Homes at Meadows
Woods

**CITY OF PORTLAND, MAINE
DEVELOPMENT REVIEW APPLICATION
PLANNING DEPARTMENT PROCESSING FORM
Planning Copy**

Stuart Street Subdivision
Project Name/Description

Secondary Submission of Homes at Meadow Woods

FRONT ELEVATION

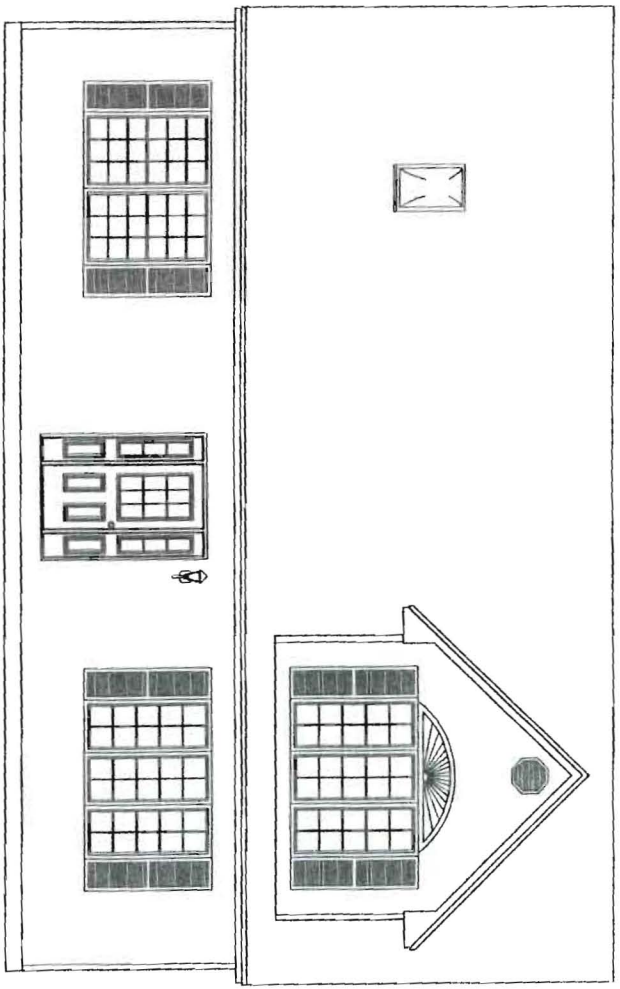
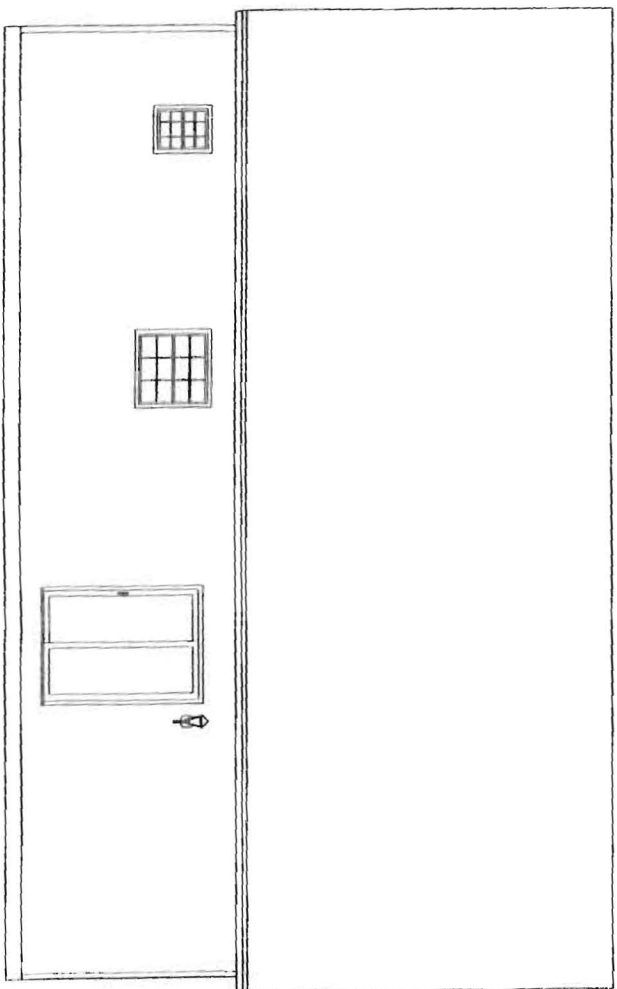
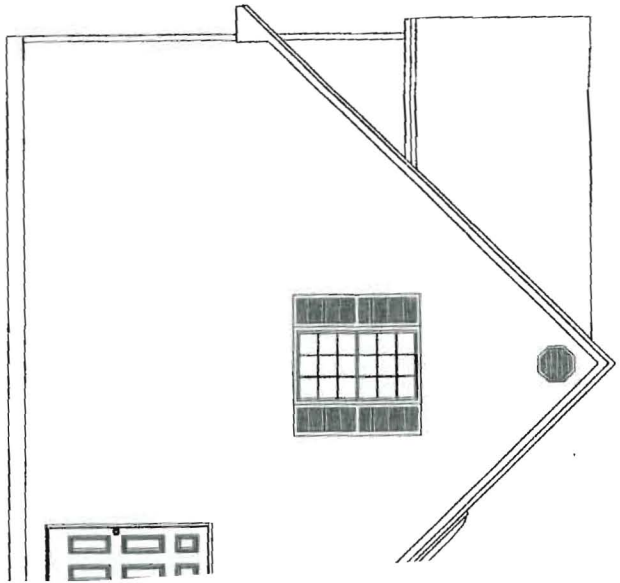
- As mentioned in the Planning Board memo, the rear and side elevations should be enhanced. One suggestion would be to add more windows on these elevations.
- A front elevation rendering should be submitted showing the relationship of the units to the garage and to one another.
- An elevation should be submitted showing the relationship of the proposed buildings to the proposed retaining wall. A cross section of the retaining wall shall be submitted along with catalogue cuts of the proposed retaining wall.

You requested enhancements on the building elevations. We have added an additional window to each end of each building on the first floor and a sky light on each unit on the rear. We have added the proposed landscaping to the elevation views and combined the units with the garages to all views. See the attached 11" x 17" color copies. Also as requested, we provided an elevation view of Units 12 and 13 with the landscaping and the double retaining wall between them.
